**Consultation Response from KC,
Lead Local Flood Authority**
2020/93954 Land at, Lingards Road, Slaithwaite, Huddersfield, HD7 5HY
Erection of 57 dwellings and associated works
**Date Responded: 30th
December 2020**
**Responding Officer: Paul
Farndale**
Responding Ref:
Summary

Kirklees Flood Management & Drainage acting as Lead Local Flood Authority, statutory consultees for surface water, OBJECTS to this application due to inadequate research of current land drainage in relation to layout design, difficulties associated with proposed surface water outfalls and additional constraints.

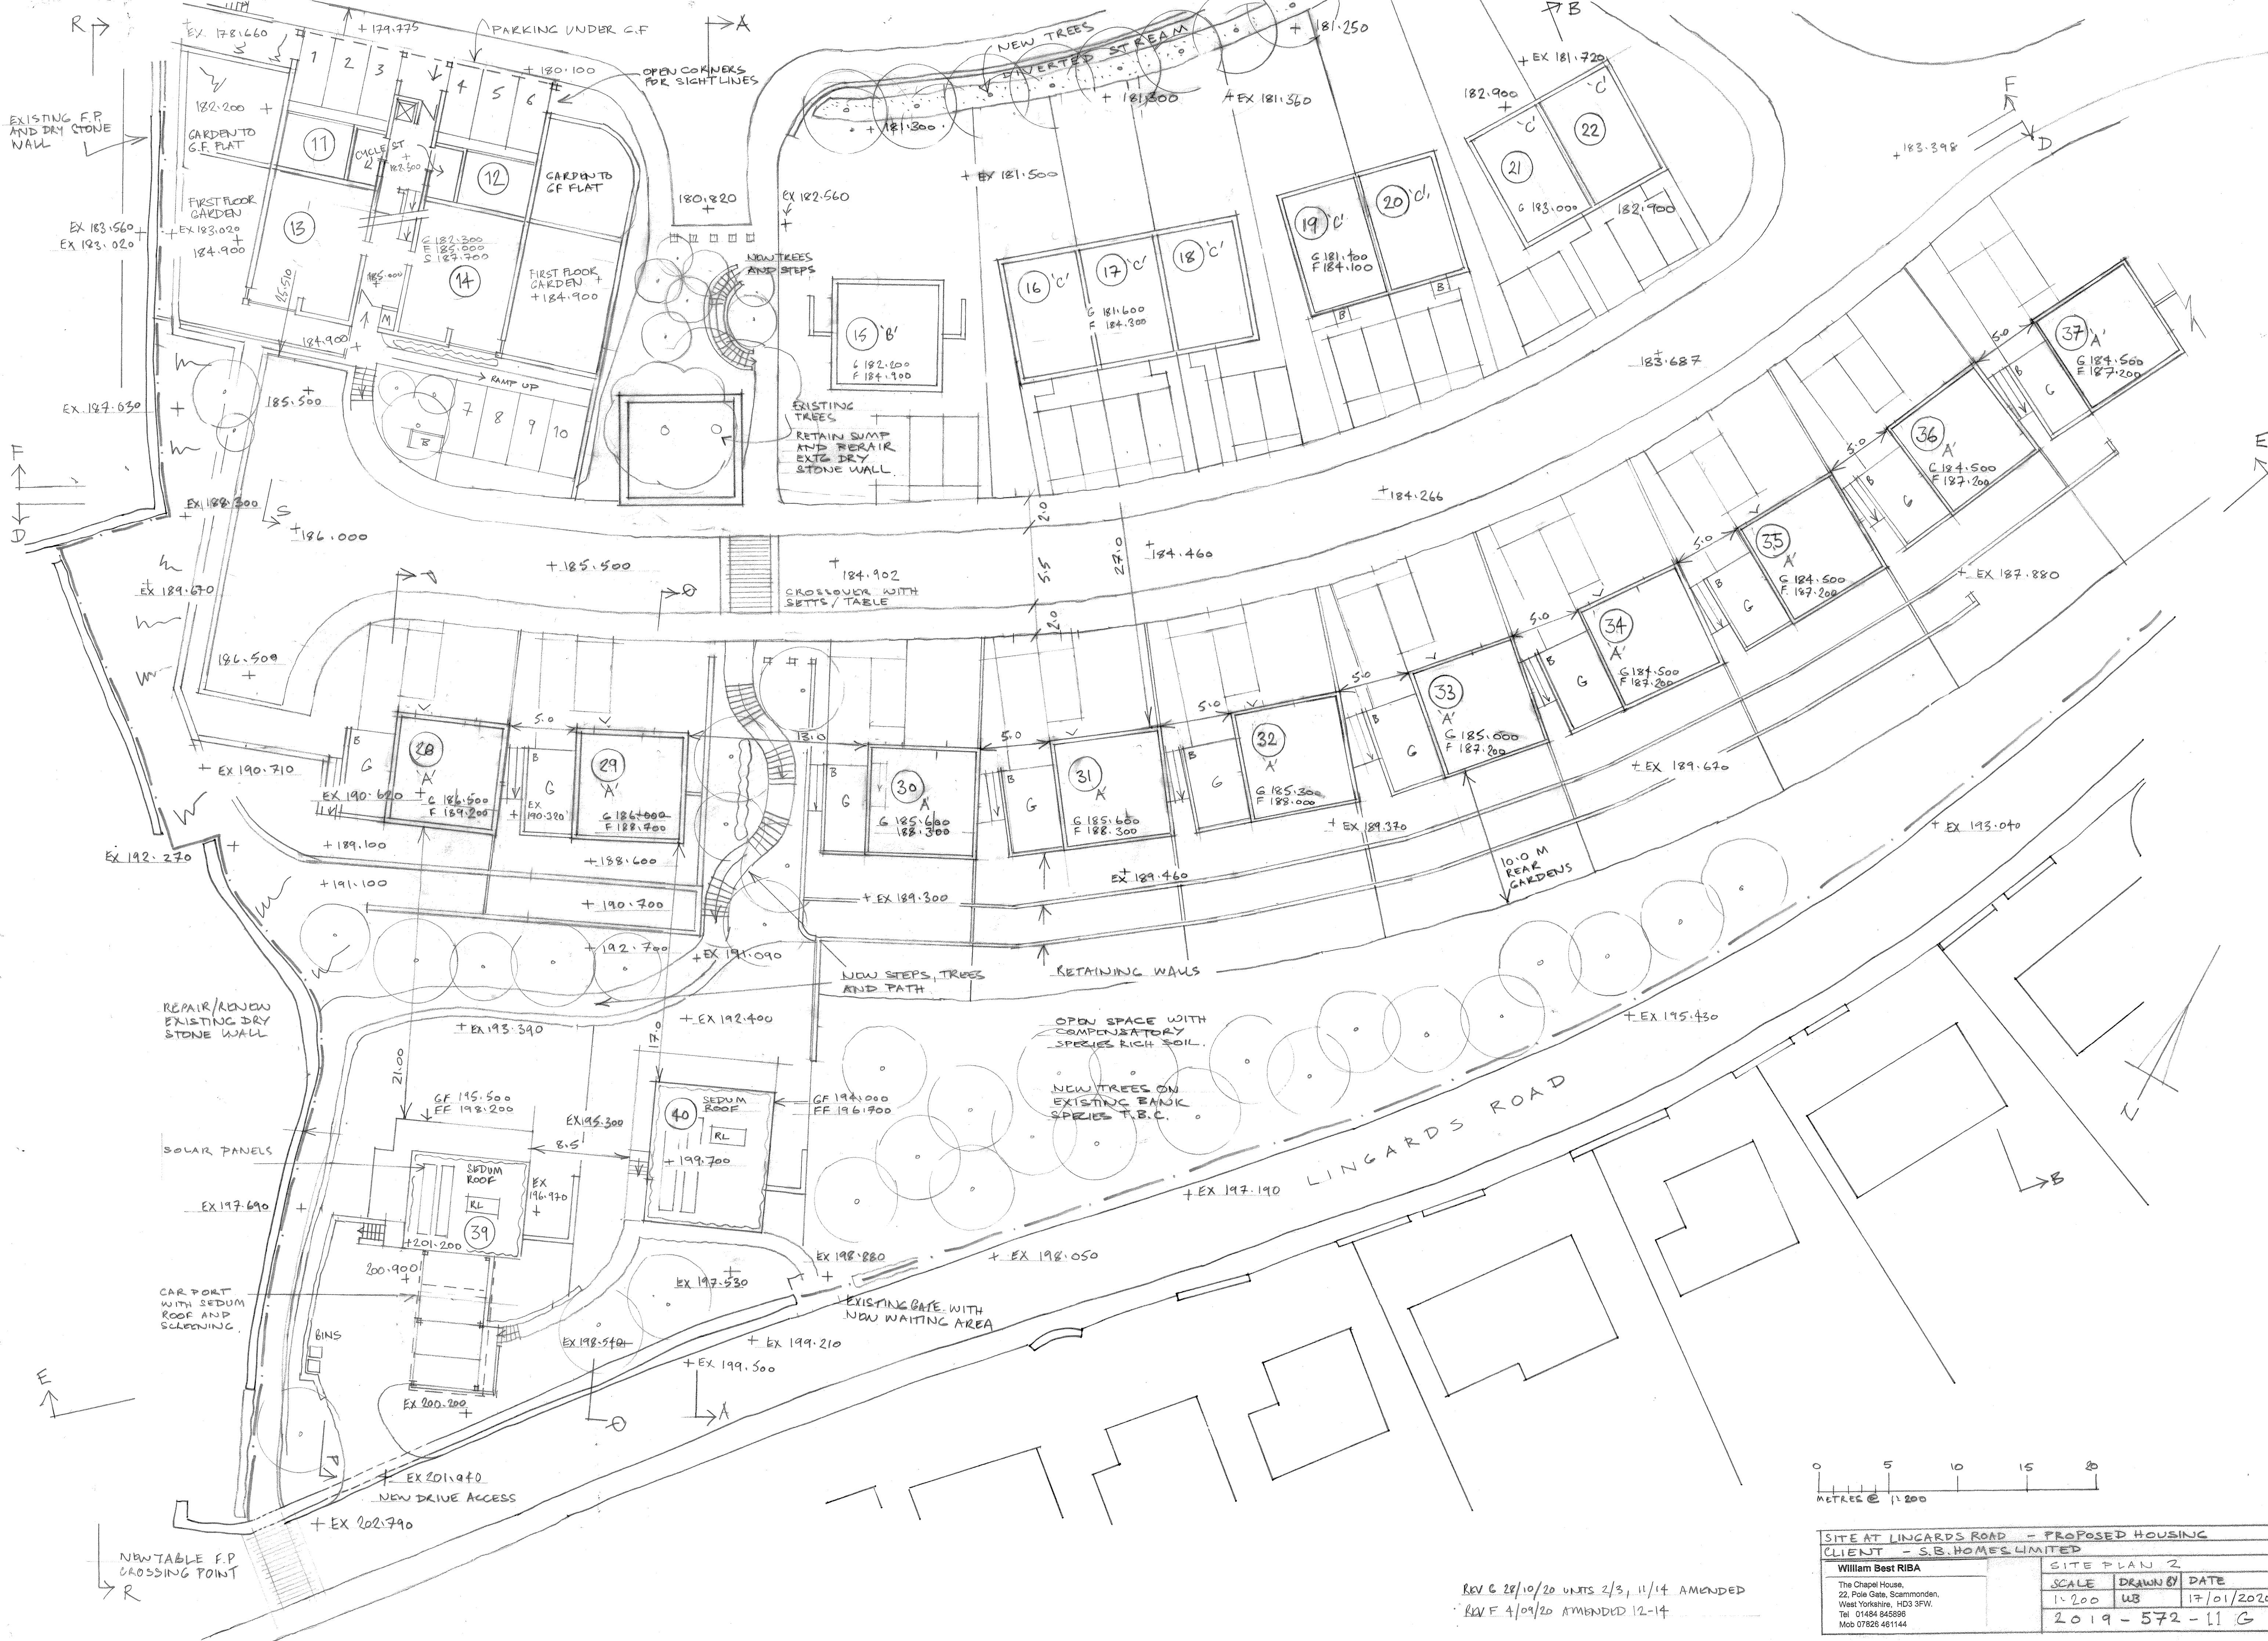
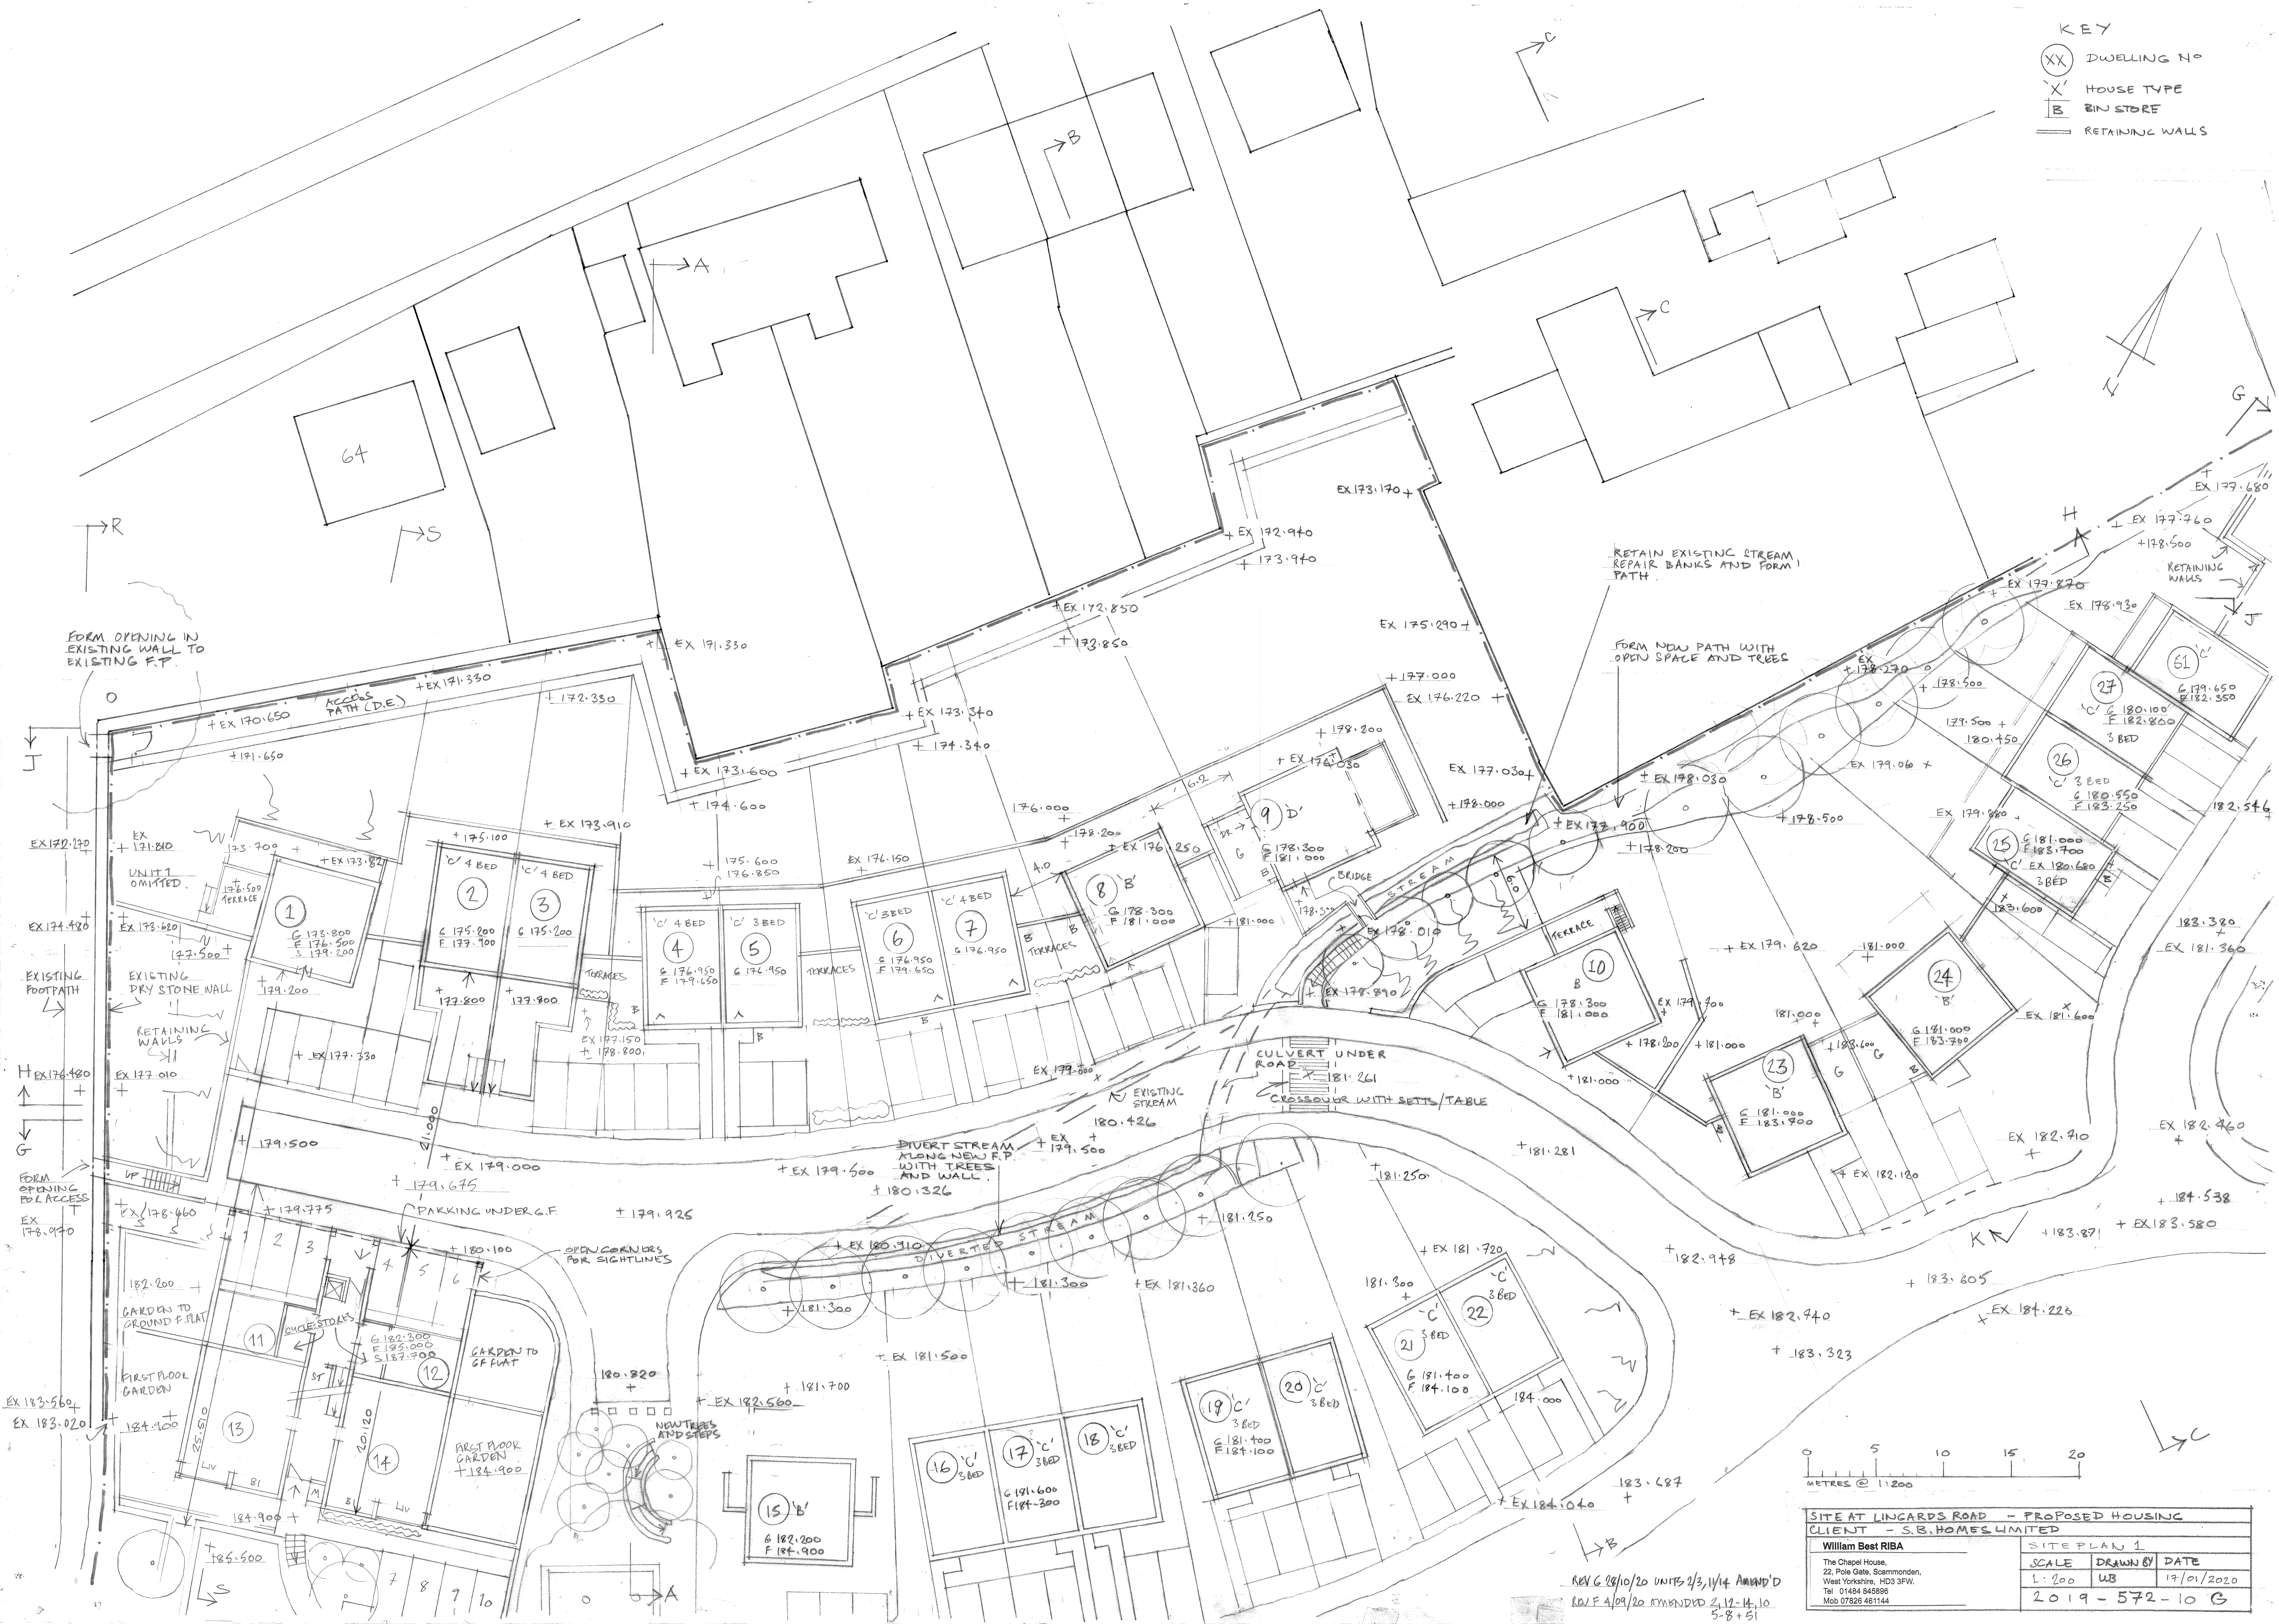
To overcome this objection, the flood risk assessment must fully understand current site drainage and clearly demonstrate how the site design fits in and adequately manages these constraints and the flood risk associated with them.

The development is therefore unsafe in its current format and the number of properties in any resubmission may need to be altered.

The ditch subsequently feeds a pond in neighbouring land where stables are located. The route thereafter is unknown. As a result, only existing flows should enter this system. Pipework and open systems will be shallow and unlikely to be able to be built over and needs to remain landscaped. They will also need to be maintained long term if a suitable layout can be agreed.
